The Planning Inspectorate
Yr Arolygiaeth Gynllunio

SCOPING OPINION:

Proposed Green Hill Solar Farm

Case Reference: EN010170

492000

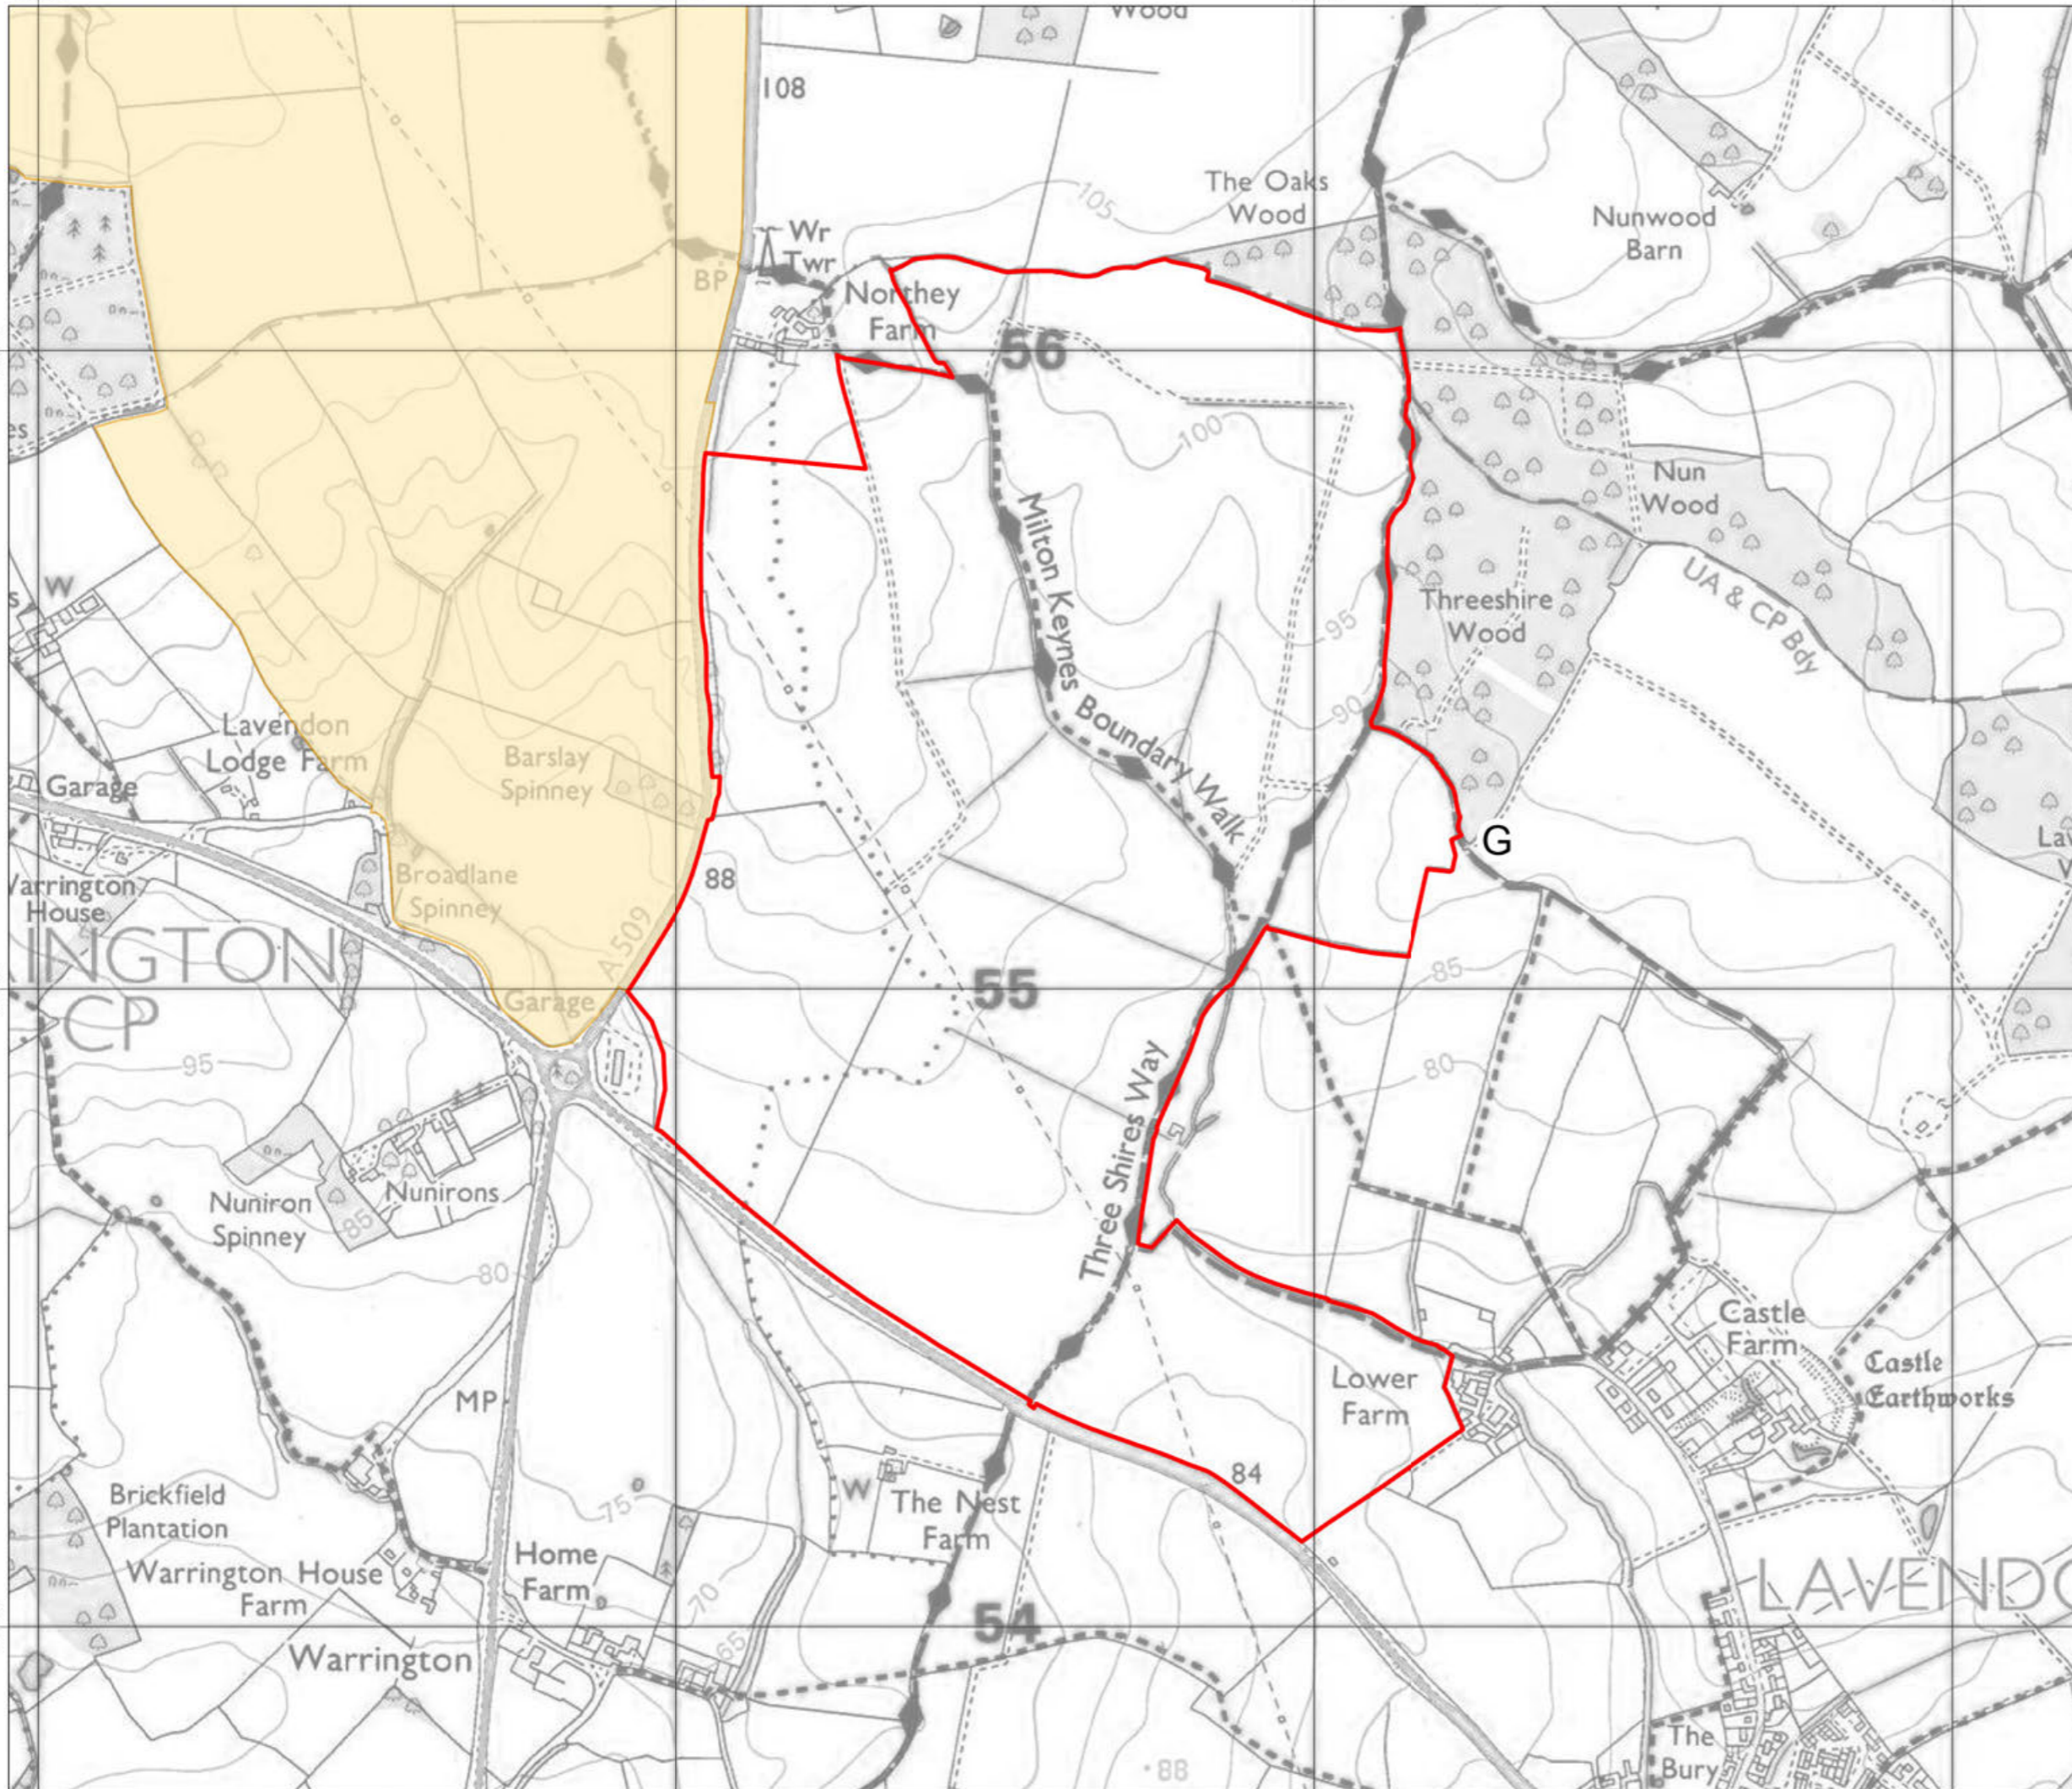
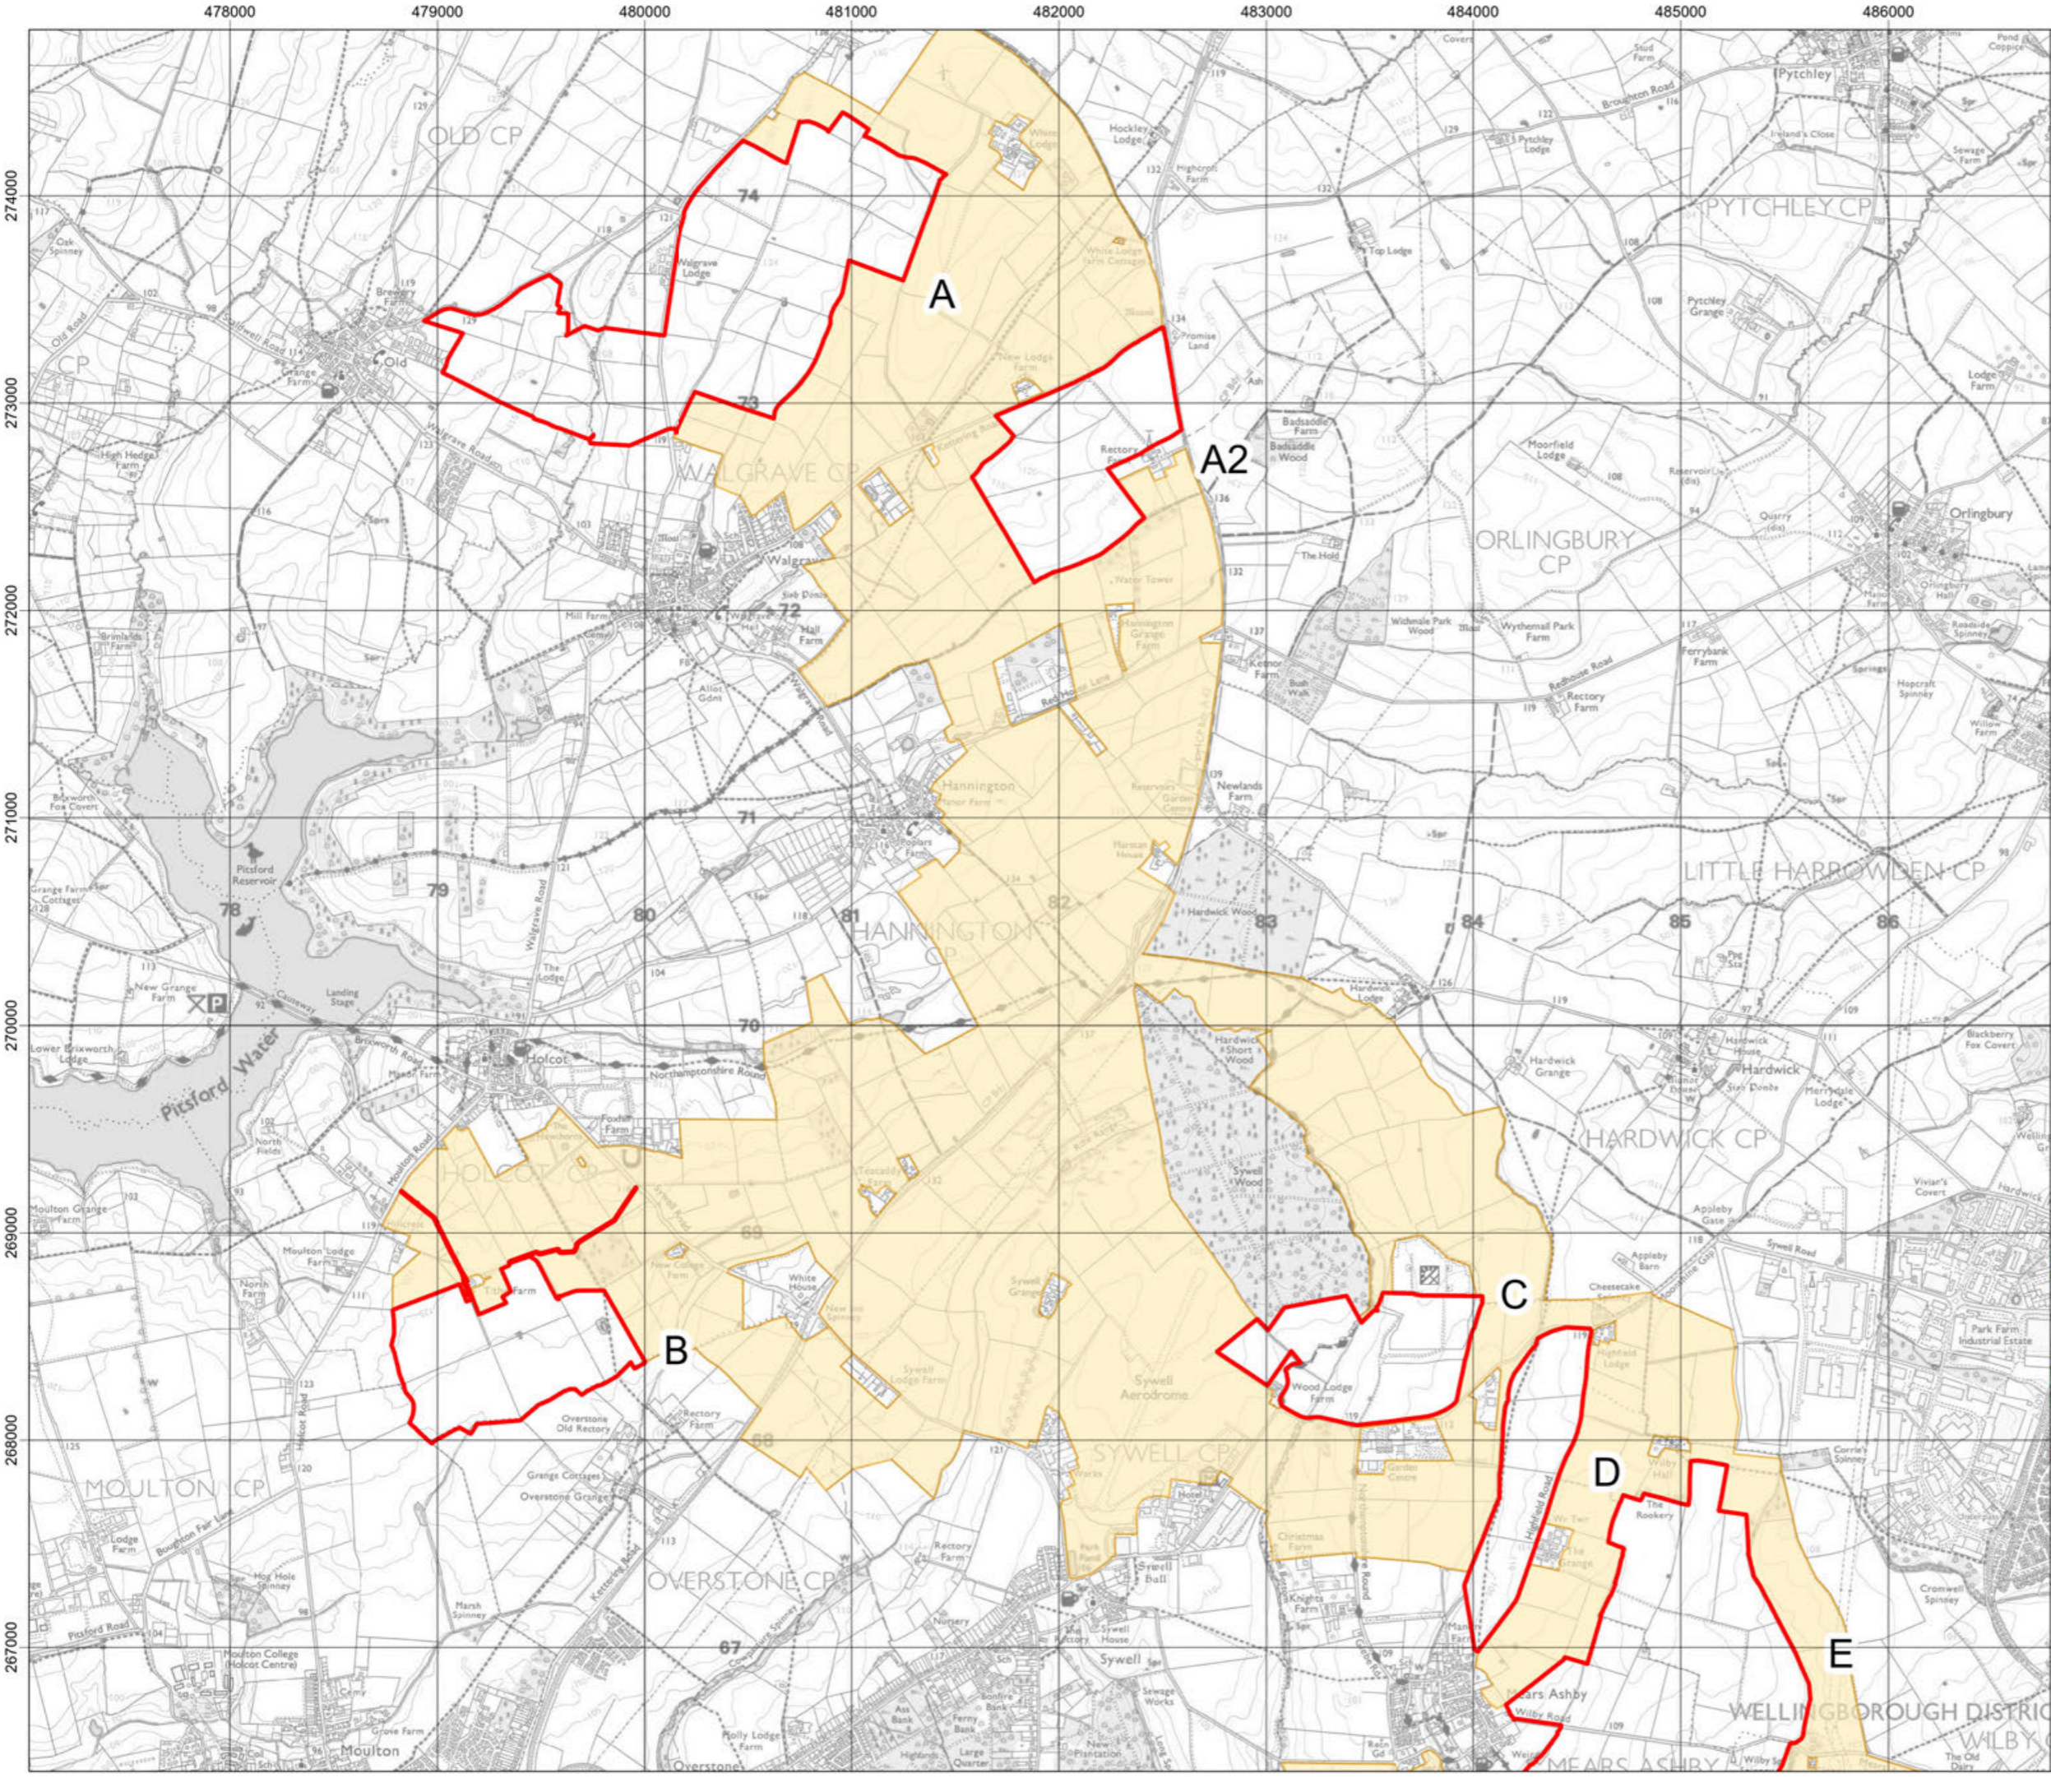
21.14		Figures – red line boundary	The Inspectorate notes that in figures provided the red line boundary denotes only the site areas that contain the solar panels and AD; and the Cable Route Search Area is hatched separately. The red line boundary depicted on the ES figures should encompass the entire application site, ie Sites A – G, the BESS site and the Cable Corridor.
